From: Matthew Eason <mj4.matt@gmail.com>
Sent: 20 May 2021 23:34
To: Iqraa Malik
Subject: Re: FG/89/21/HH Revised plans
Attachments: We sent you safe versions of your files; 25 Ocean Drive - Proposed Elevations REV 5.pdf; 25 Ocean Drive - Proposed Roof and Plan View REV 5.pdf

Unfortunately, this application is still invalid for the following reasons:

Ref - FG/89/21/HH - 25 Ocean Drive

Proposed Layout and Roof
Scale 1:50 @ A1

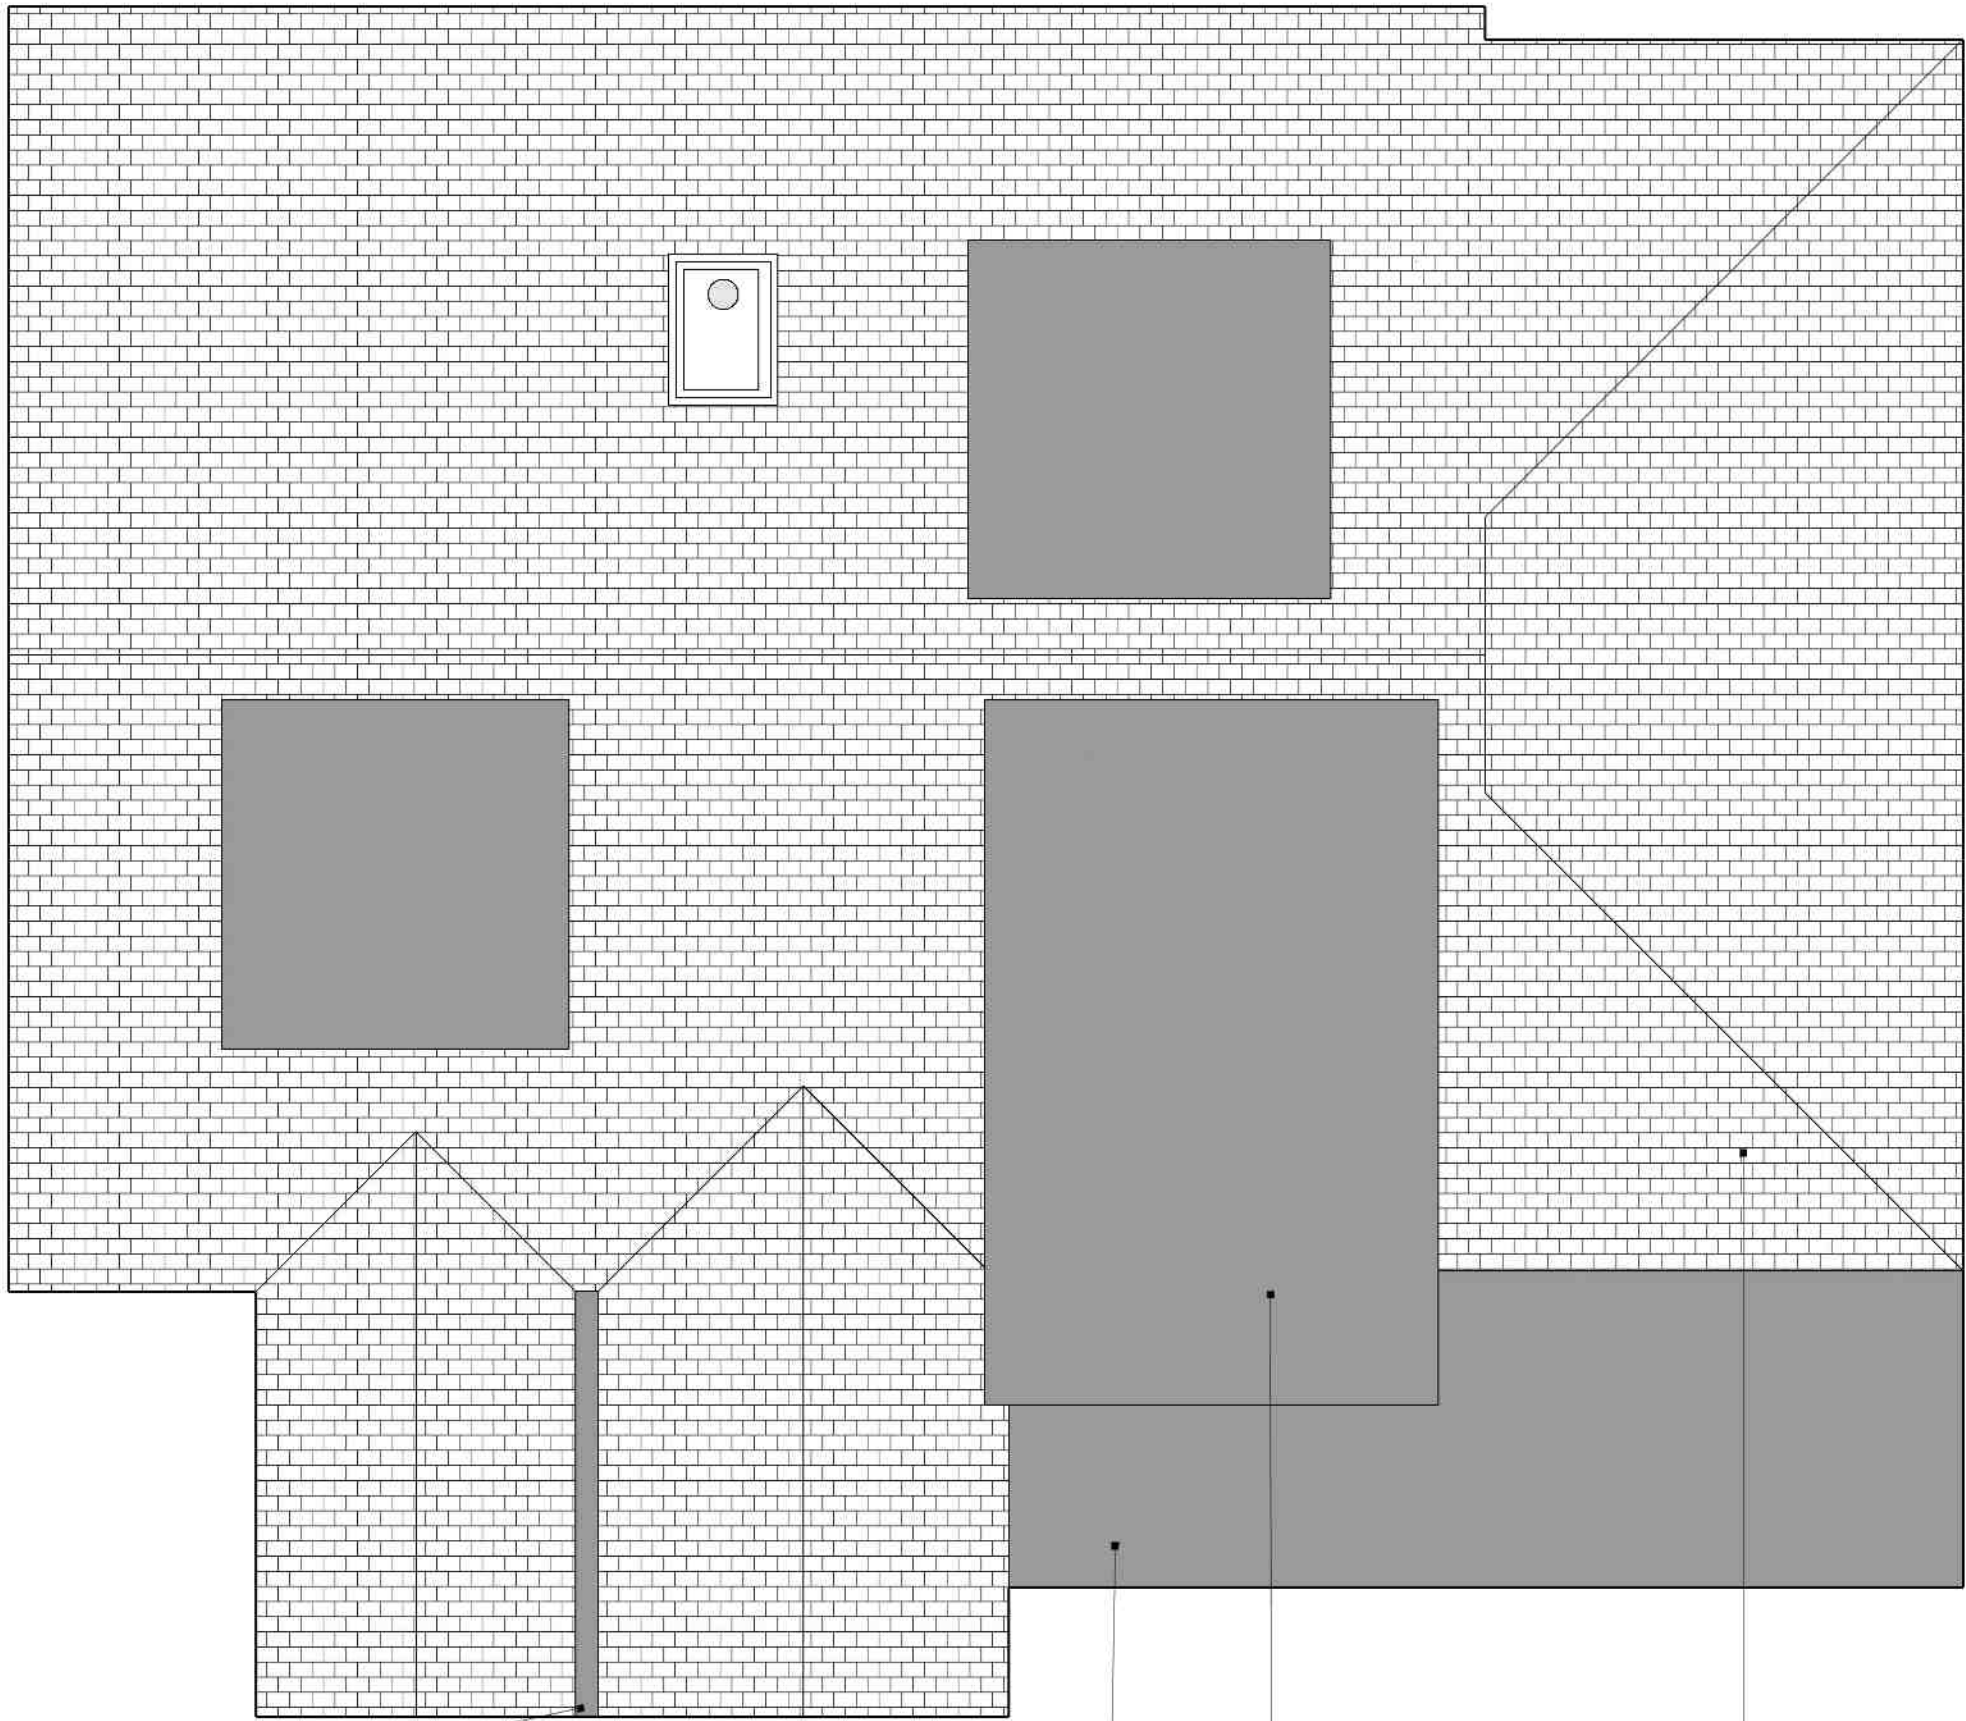
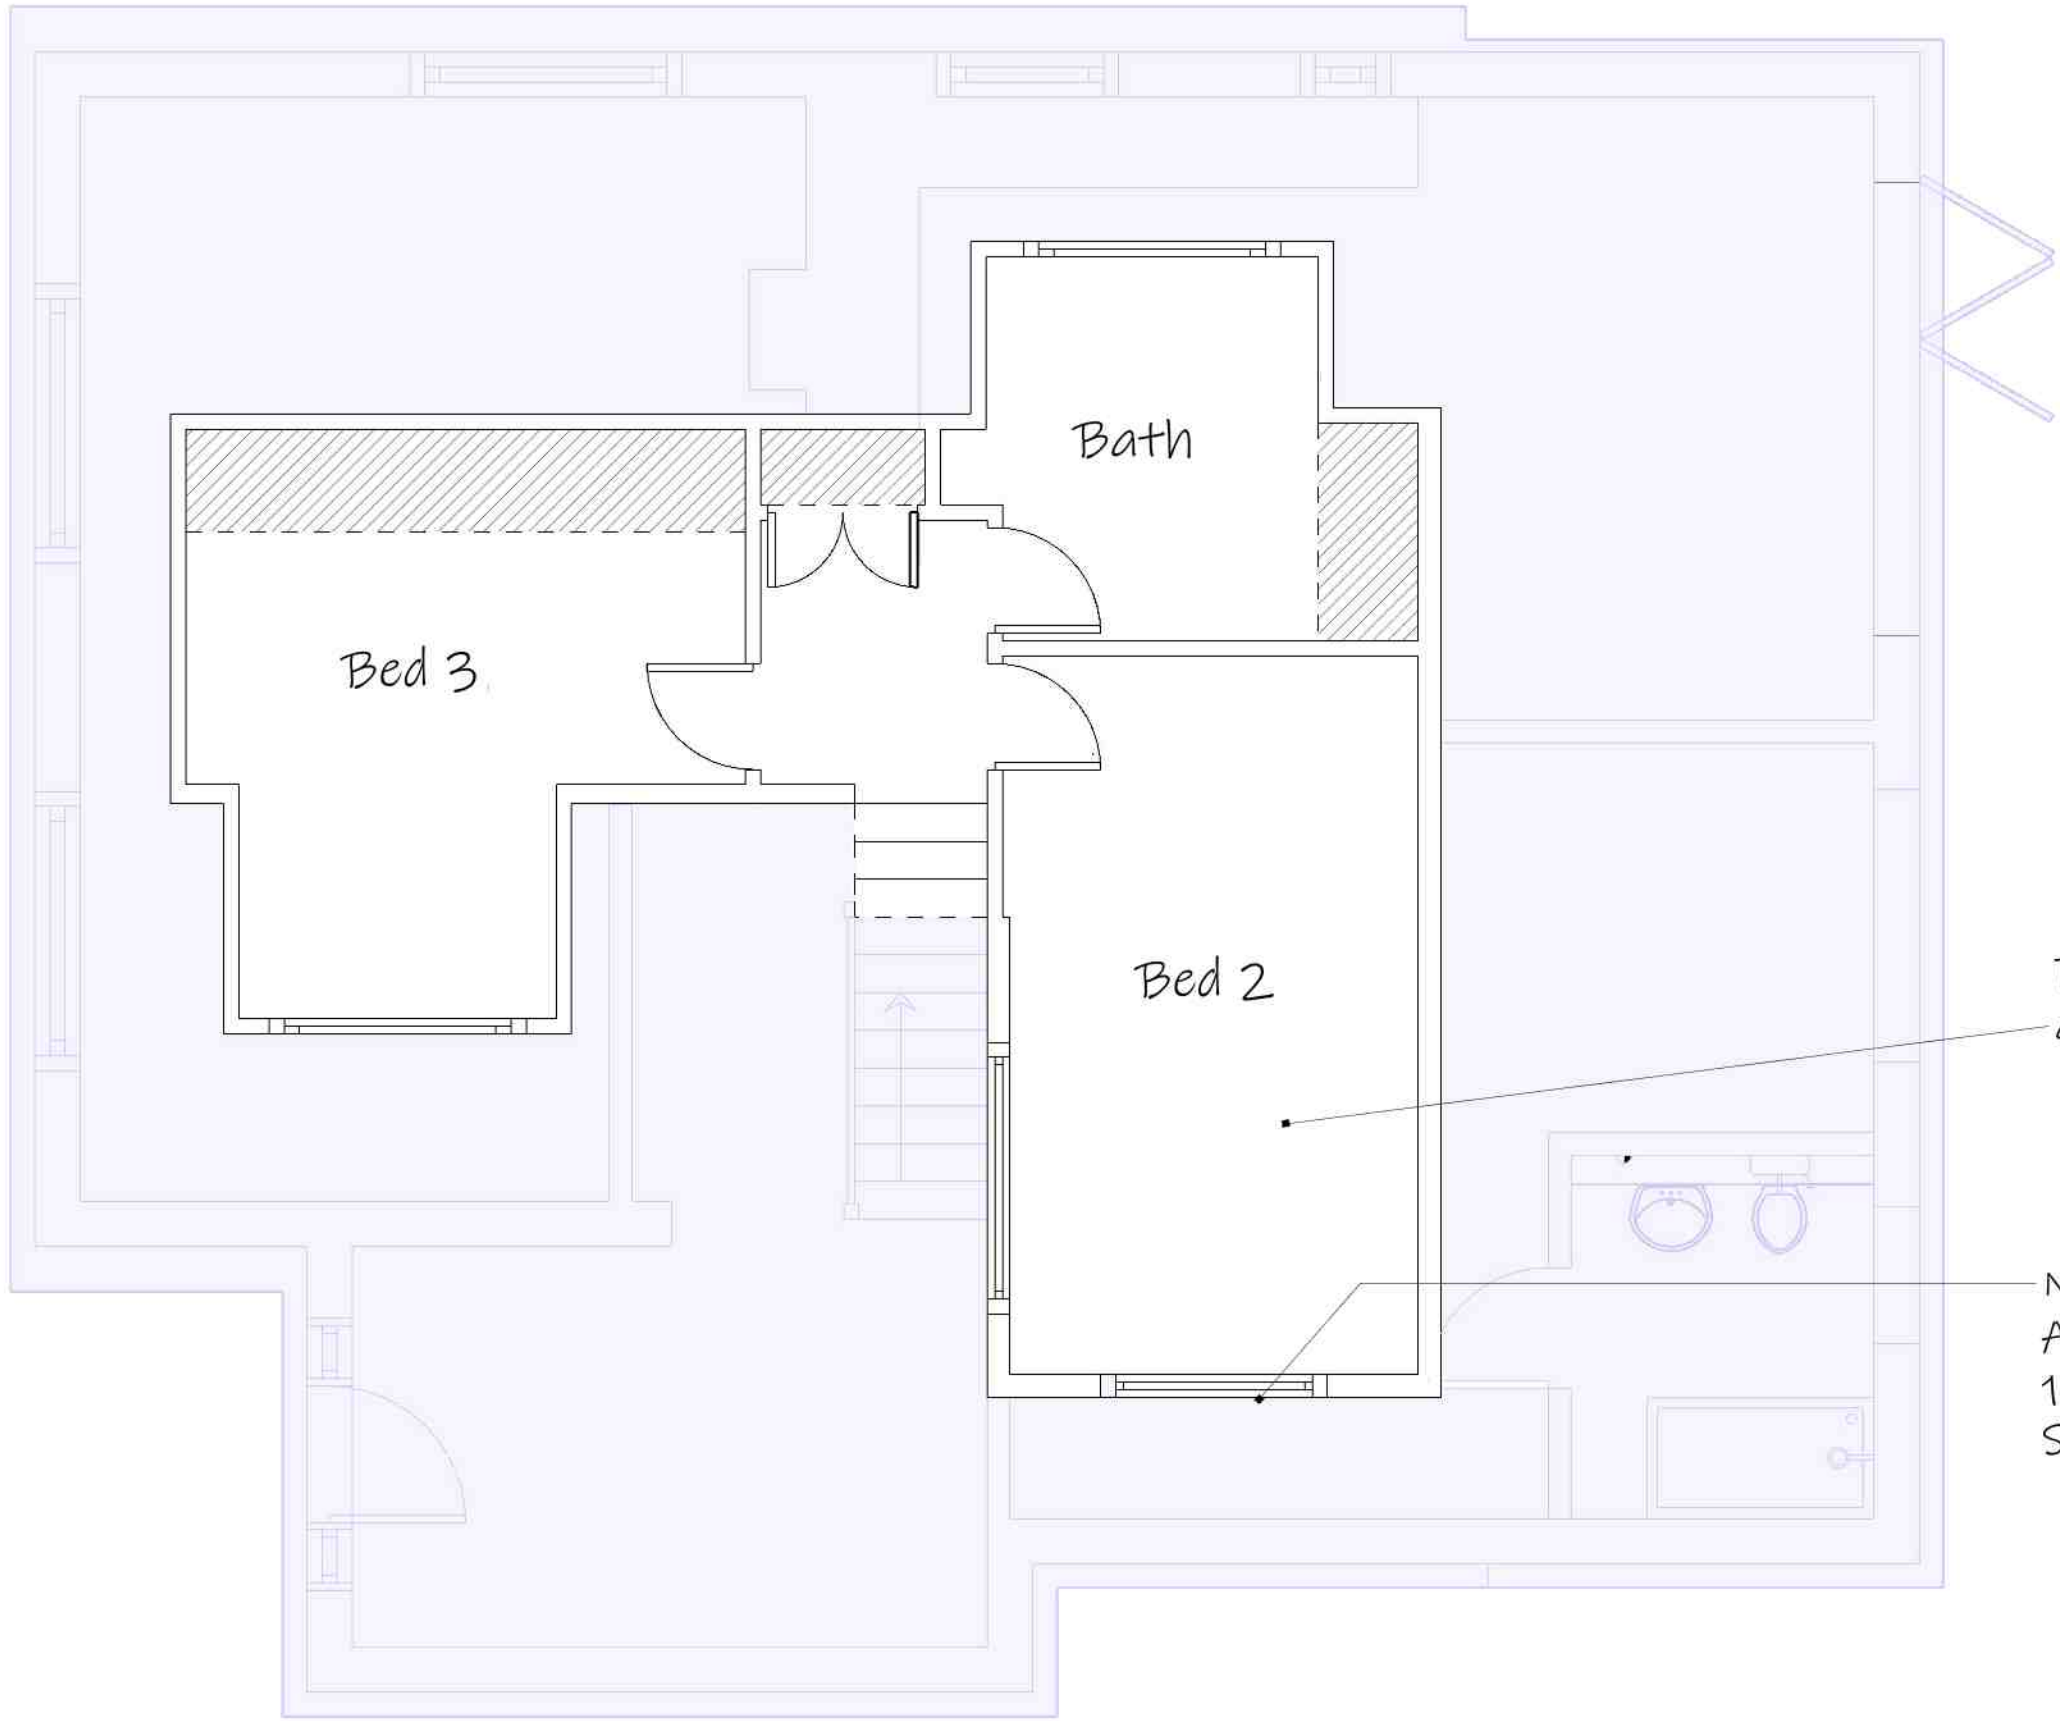
Proposed Plans: The rear window shown on the proposed first floor is missing from the proposed rear elevation

Proposed Plans: The ground floor window placement is inconsistent between the proposed ground floor plan and the north elevation.

The above mentioned window has been removed from the 1st floor plan.
